WEST SUSSEX COUNTY COUNCIL CONSULTATION

TO:	Arun District Council FAO: Mr A Wood
FROM:	WSCC - Highways Authority
DATE:	2 April 2019
LOCATION:	Land Adjacent Station Cottages, Ford Road, Ford, BN18 0BH
SUBJECT:	F/9/19/PL Change the use of 1/2 the site area to a hard standing storage area.
DATE OF SITE VISIT:	N/A
RECOMMENDATION:	More Information
S106 CONTRIBUTION TOTAL:	N/A

Block Plan shows area bounded by: 500225.07, 104198.15 500277.07, 104250.15 (at a scale of 1:200), OSGridRef: TQ 25 422. The representation of a road, track or path is no evidence of a right of way. The representation of features as lines is no evidence of a property boundary.

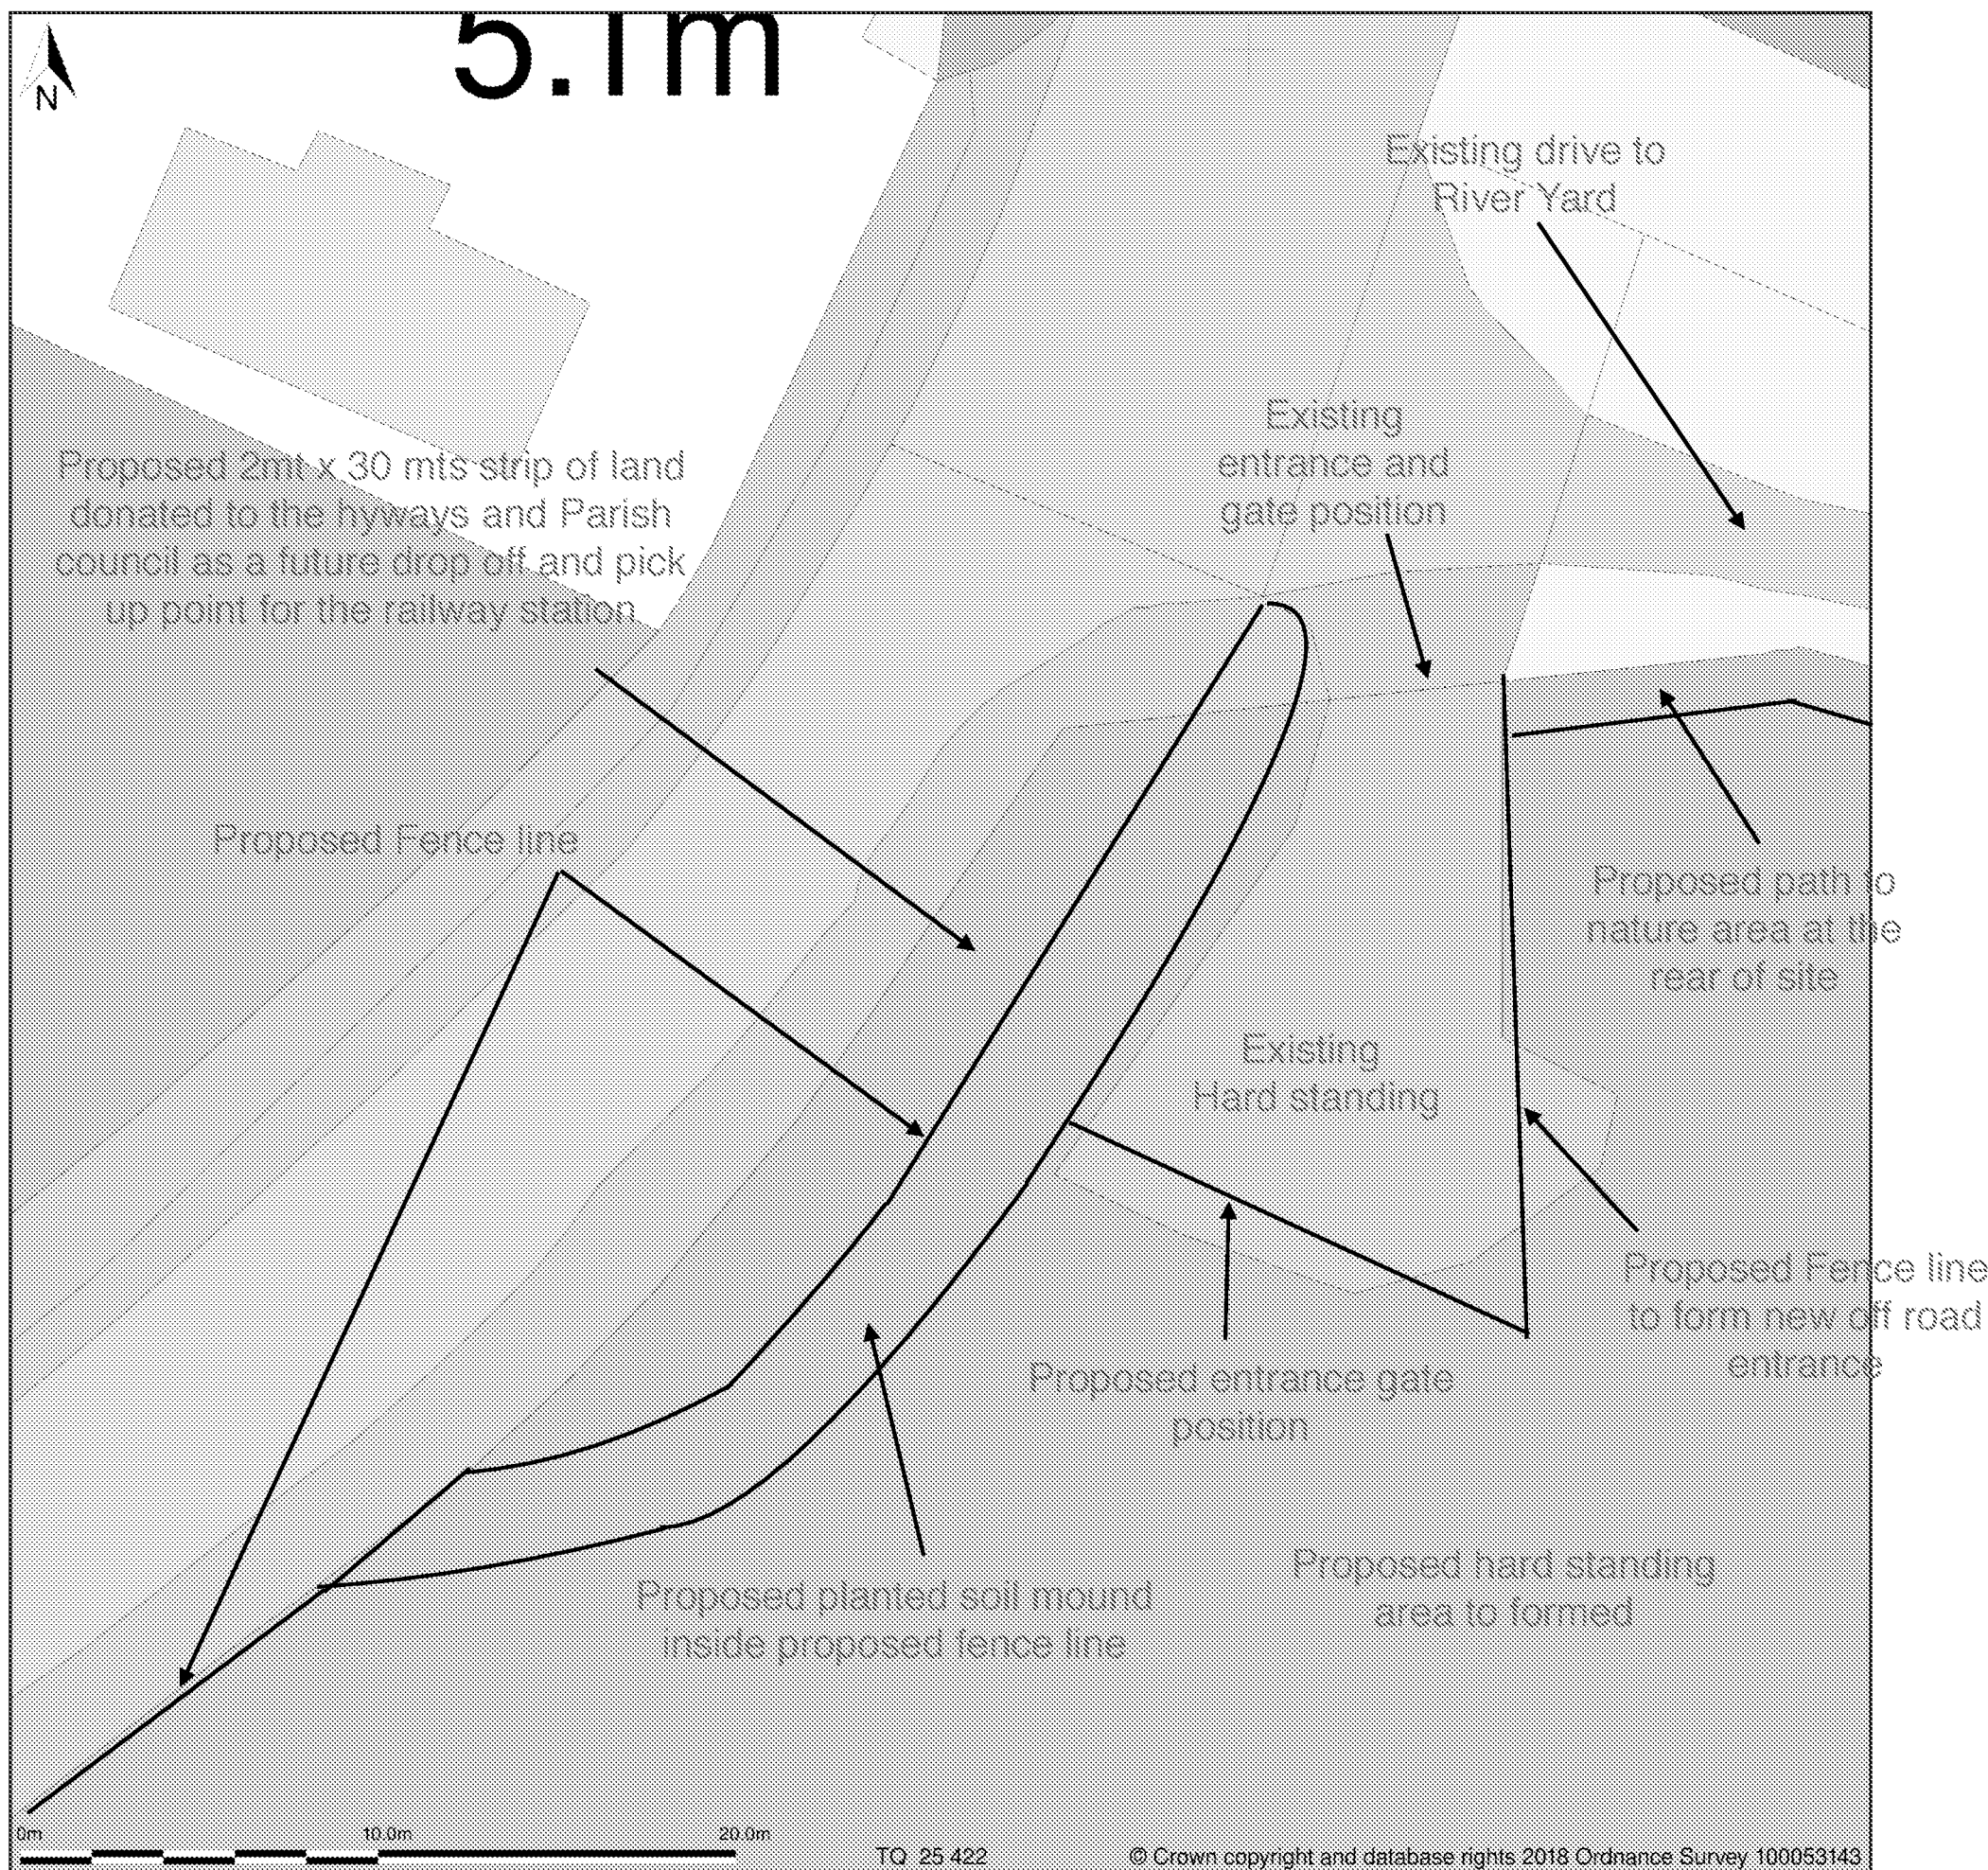
The existing site access exits onto the junction of the existing private access with Ford Road. The applicant does not propose to alter the existing access width of the private access way.

The applicant has not provided visibility splays to support the intensification of use of the site. As Ford Road is subject to a speed limit of 40mph, Design Manual for Roads and Bridges (DMRB) TD9/93 is the appropriate standard in this location. This sets out a Stopping Sight Distance of 120m in each direction. Splays should be drawn from a distance of 2.4m back into the access to the nearside edge of the carriageway in each direction, or at an offset of 1m to represent the track of a vehicle. The splays should utilise land only within the control of the applicant, or within the highway boundary.

The applicant has outlined that the storage use will include the storage of boats and caravans. The applicant is requested to demonstrate via swept path tracking that vehicles can enter and exit onto the public highway in each direction. It is noted that this access has the potential to be used for agricultural vehicles currently due to the existing agricultural use, however this is anticipated to be a less frequent use than that proposed.

The applicant is requested to provide a site layout plan indicating the location of proposed metal containers and any other buildings or structures on the site. A proposed parking layout plan should also be provided and details should be provided demonstrating that vehicles, including the largest anticipated vehicle, can turn on site and exit onto the public highway in a forward gear.

Proposed Fence ans earth monud elevation

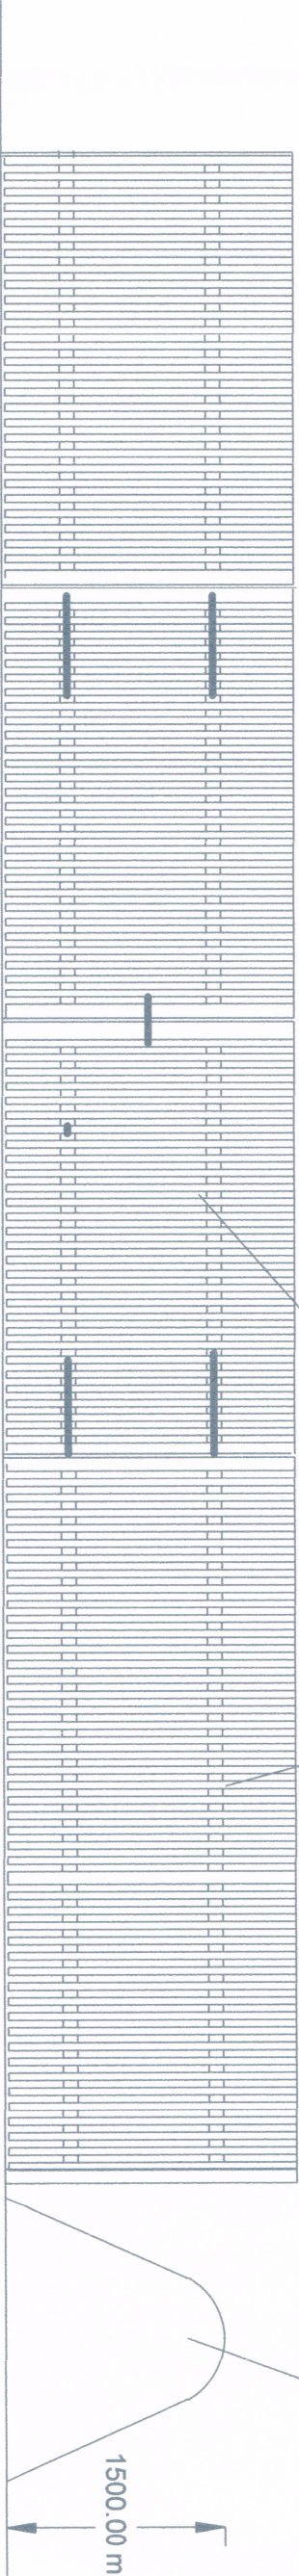
The applicant proposes to erect a fence along the site boundary. The provided elevation plans do not indicate the height of the proposed fence, although from comparison to the proposed mound, this will be greater in height than 1.5m. The proposed fence appears to follow the site boundary and does not appear to encroach on highway boundary land. However, the applicant should be aware that the proposed fence positioned to the north of the site, abutting the edge of the junction with Ford Road, must not encroach upon highway land and must not obstruct any proposed visibility splays. The applicant should also take this proposed fence into consideration when demonstrating swept path tracking for vehicles entering and exiting the site.
